**CITY OF MERCER ISLAND**

August 29, 2017

RE: ADU17-003, CAO17-005, SHL17-007, SUB17-004 Second Review Letter  
Land Use Applications for proposed home, ADU, driveway and retaining wall construction within  
a steep slope along the shoreline for the Lady Bug Trust. DEV17-009 Impervious Surface  
Deviation Application has been withdrawn.

1 ADU - south elevation
1/4" = 1'-0"

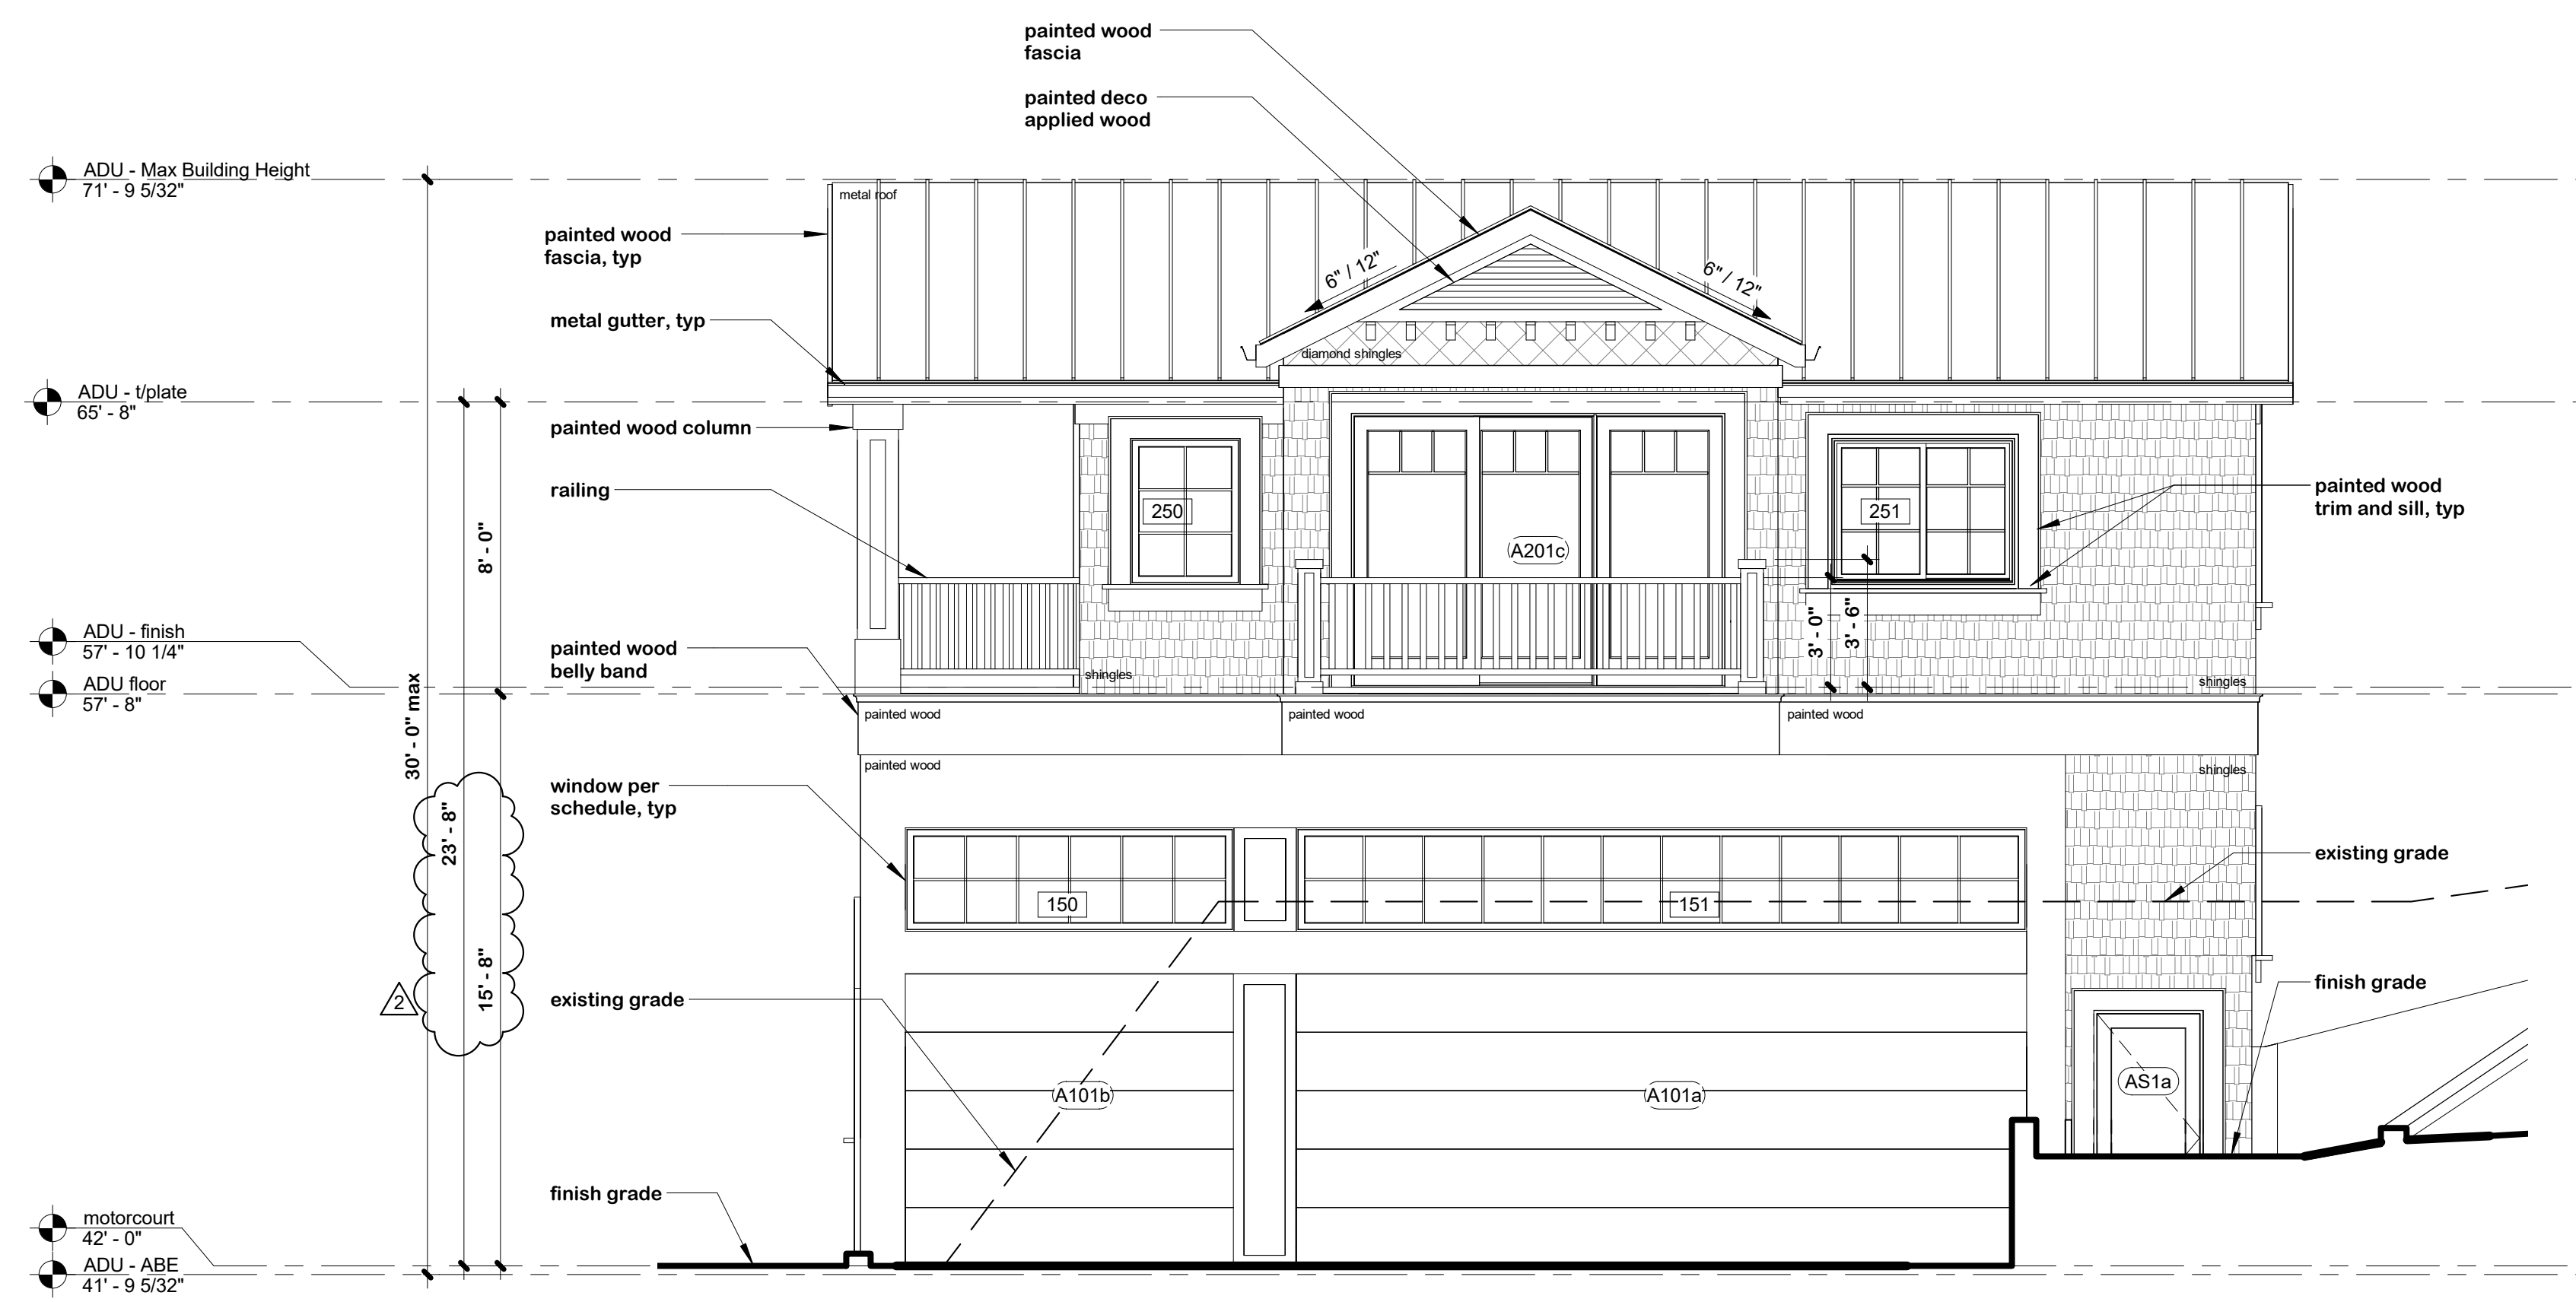
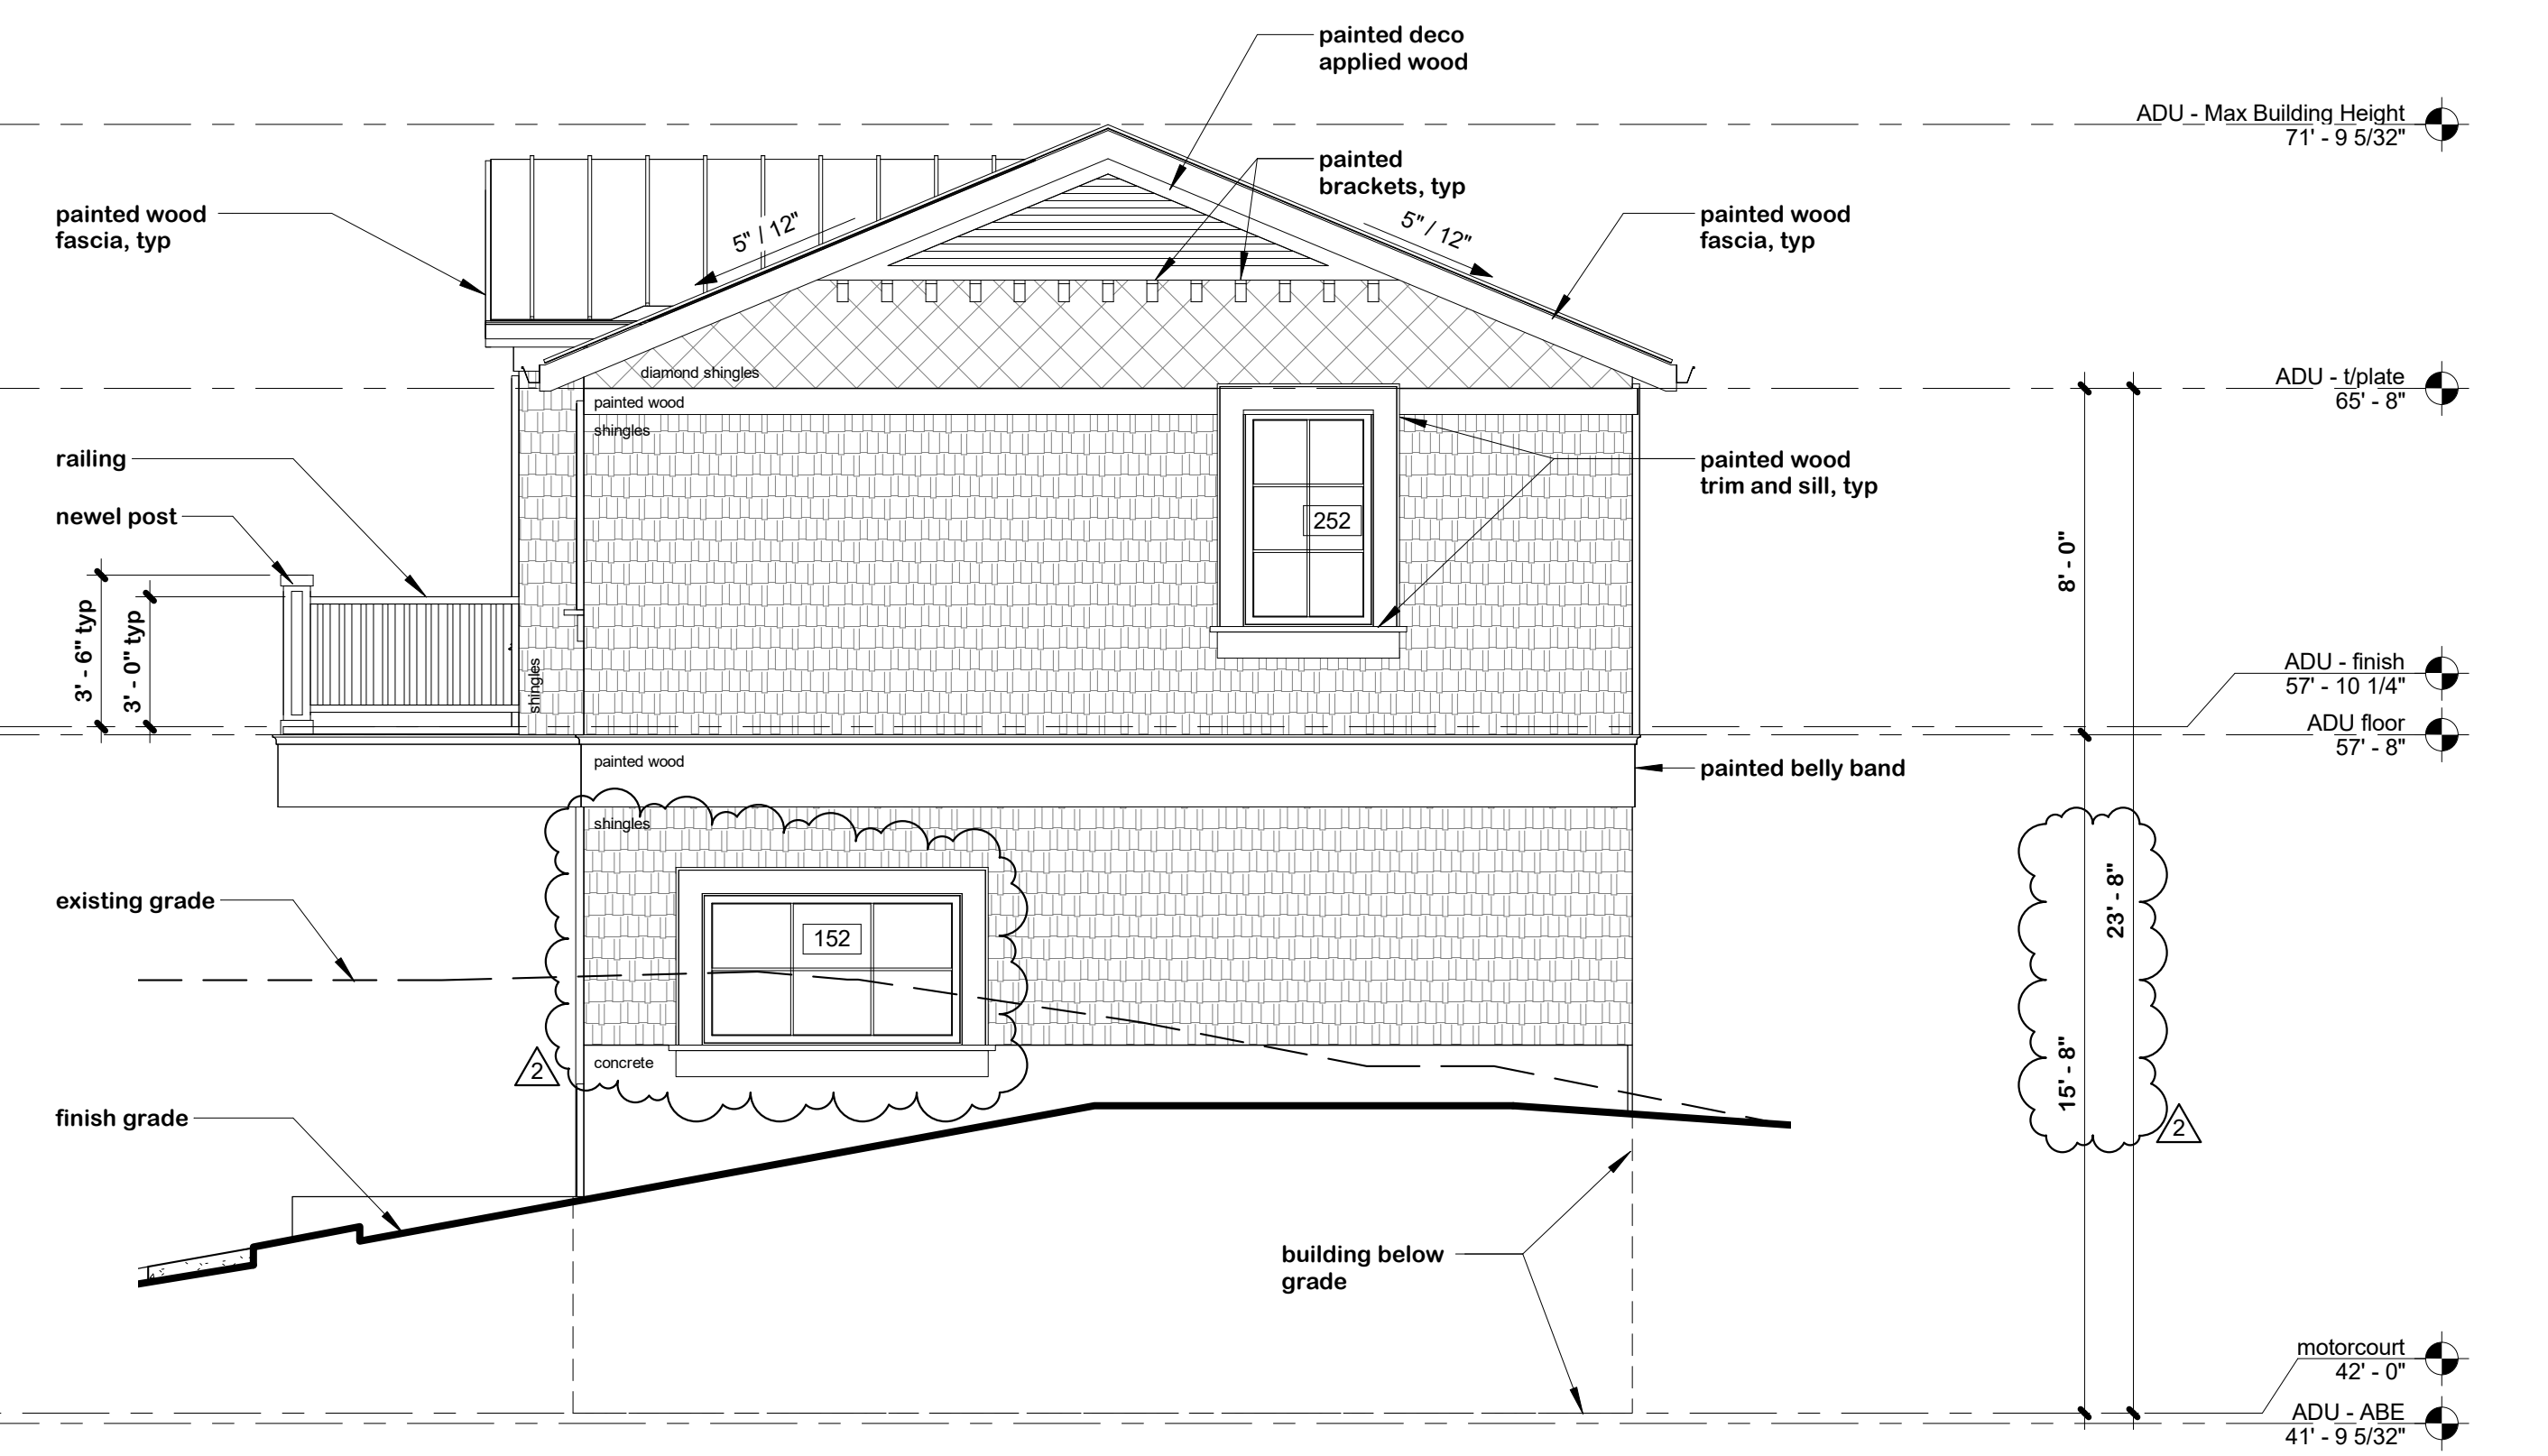
8. Please provide building elevation drawings that the ADU shall be designed consistent with the existing roof pitch, siding, and windows of the principal dwelling unit.
